WEST SUSSEX COUNTY COUNCIL CONSULTATION

TO:	Arun District Council FAO: Anita Gardner
FROM:	WSCC - Highways Authority
DATE:	14 October 2019
LOCATION:	Mill Ball, Binsted Lane, Binsted, BN18 0LJ
SUBJECT:	WA/97/19/PL 1 No. replacement dwelling.
DATE OF SITE VISIT:	N/A
RECOMMENDATION:	Advice
S106 CONTRIBUTION TOTAL:	N/A

GROUND FLOOR PLAN - 29.07.19
SCALE @A2 1:100

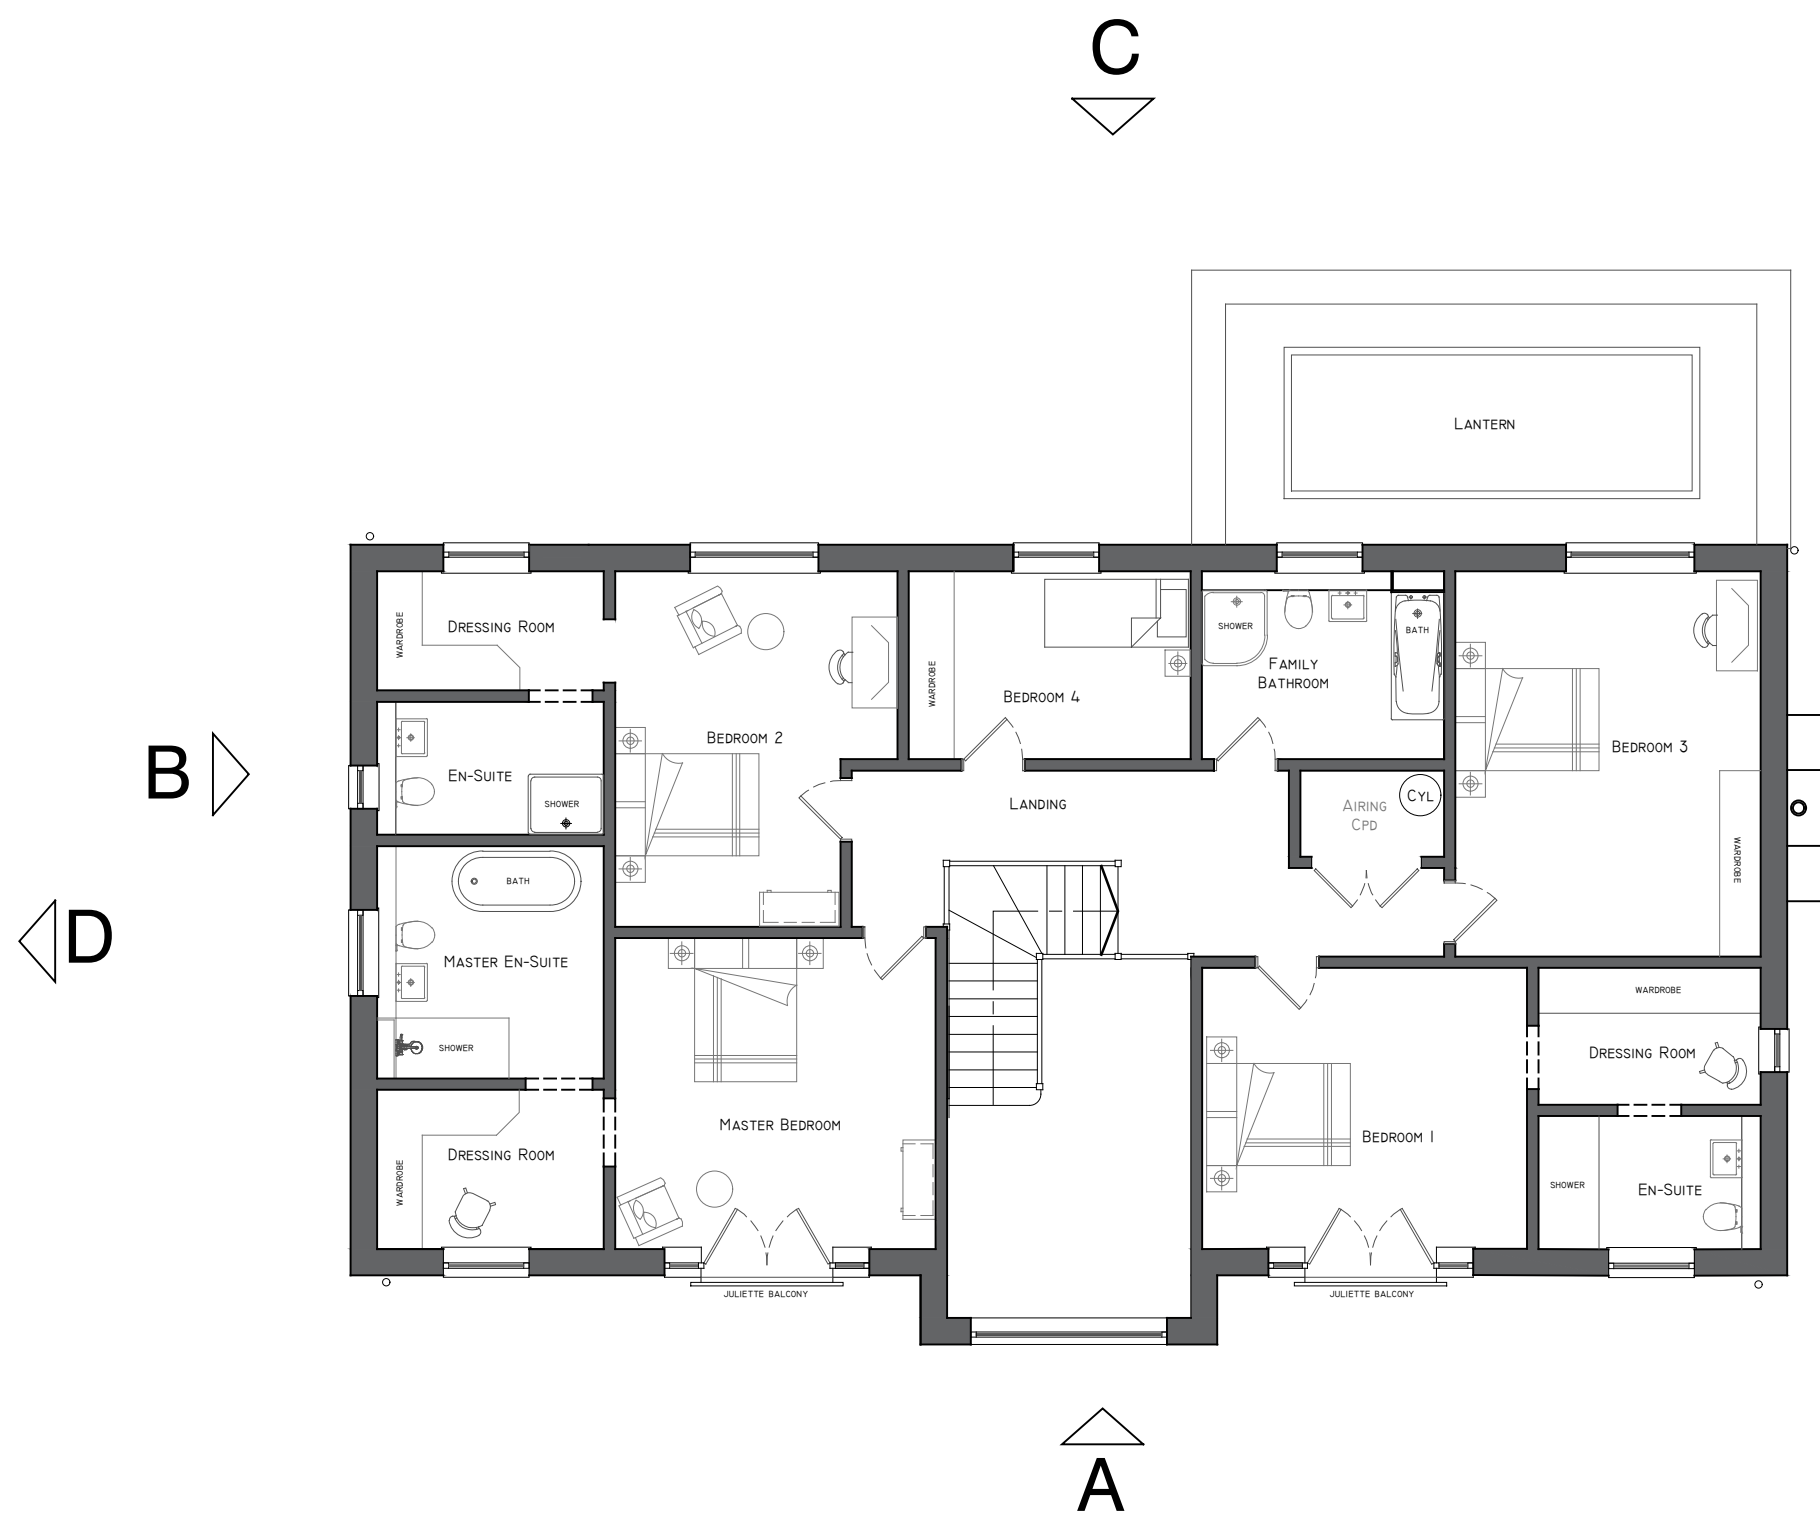
4 cycle parking spaces are proposed for this development. However, this was not demonstrated in the plans. Under WSCC parking standards, dwellings with 5 or more rooms would require at least 2 secure and covered cycle parking spaces. The inclusion of cycle parking helps promote the use of sustainable alternative modes of transport to the private car.

No part of the development shall be first occupied until covered and secure cycle parking spaces have been provided in accordance with plans and details submitted to and approved by the Local Planning Authority.
